KIRKLEES METROPOLITAN COUNCIL INVESTMENT & REGENERATION SERVICE

DELEGATED DECISION TO DETERMINE PLANNING APPLICATIONS

Reference No:	2023/62/93023/E
Site Address:	Woodlands, 4, Highbridge Lane, Skelmanthorpe, Huddersfield, HD8 9JY
Description:	Demolition of existing conservatory and erection of replacement orangery
Recommending Officer:	Nicole Helliwell

Officer Report

Drawing:
Scheme As Proposed

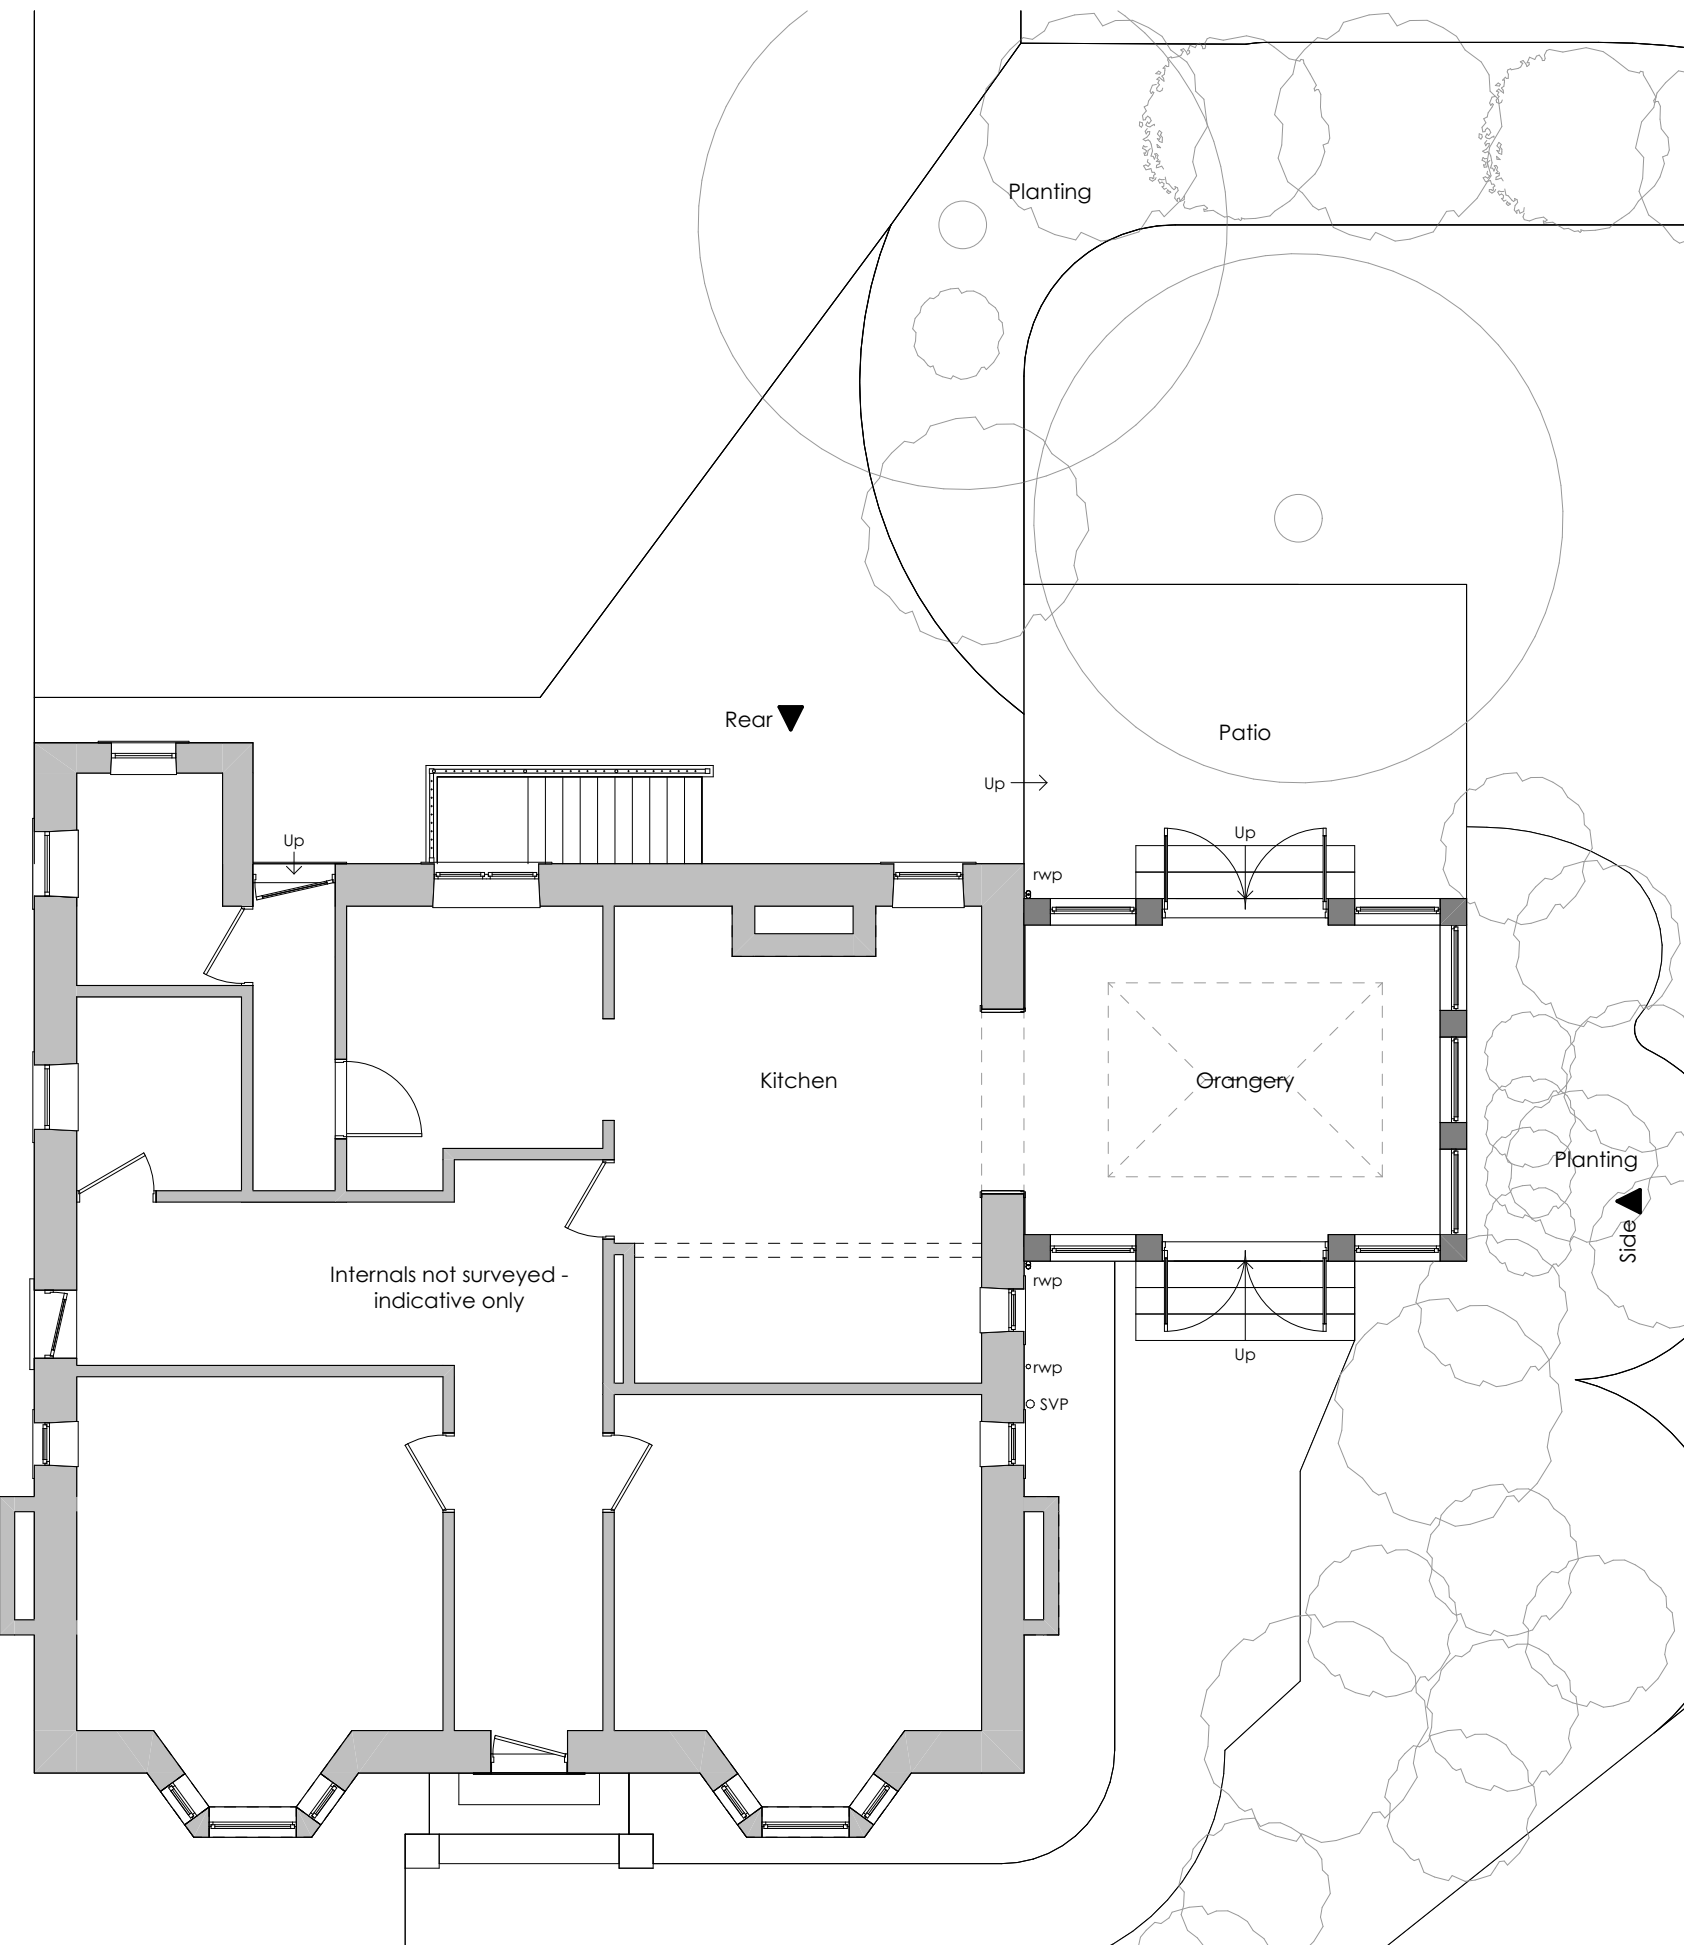
The proposed single storey extension would project approximately 5.85m from the side elevation of the original dwellinghouse. The extension would be faced in cut stone and would incorporate a flat roof with an aluminium framed roof lantern. Although this feature would generally constitute poor design, the extension would be concealed by the existing boundary treatments and would have limited visibility from public vantage points. The extension would also project further than 4m and would exceed 4m in height, however, it would appear subservient and would have an acceptable scale relative to the original build. Furthermore, it is considered that the property and its curtilage would support the extension without it appearing incongruous. Therefore, it is considered that the proposed development would respect the character and appearance of the host property and wider street scene.

The submitted plans confirm that the patio area adjacent to the existing conservatory would be extended as part of the application. The proposed works would be of a domestic scale and would not have any significant visual impact on the character and appearance of the host property.

The Council's mapping system confirms that two protected trees (06/18/t6 & 06/18/t7) are located within the application site. As such, KC Trees were formally consulted on the application. From a trees perspective the proposed replacement orangery has effectively same footprint of the existing conservatory and is not considered a concern. However, there is also a proposed extension to the existing patio area. Although it will be well within the RPA of the adjacent tree, how the existing patio is demolished, and the new patio area is installed is very important.

The new patio surface must be established above the existing levels of the RPA and the ground must not be skimmed to establish the new hard surface at the former ground level. A geo-textile membrane should be laid out in position to allow drainage, separation and prevent pollution of roots. A Cellular Confinement System (CCS) should also be pinned out in position, using road pins and taking care to avoid any roots. The CCS should be backfilled with clean aggregate (no-fines stone to allow water percolation and gaseous exchange) and the first layer of CCS must be infilled by hand, to prevent any machinery from tracking over any unprotected root protection areas. The subsequent layers of CCS must be infilled with machinery only running on filled CCS and not the exposed surface of the RPA, by starting work from outside the RPA, working inwards.

3. The orangery hereby approved shall be faced in cut stone for the external walls with a flat roof in grey with a powder coated aluminium lantern. The materials of construction shall thereafter be retained for the lifetime of the development.

4. The patio hereby approved shall be constructed using a Cellular Confinement System (CCS).
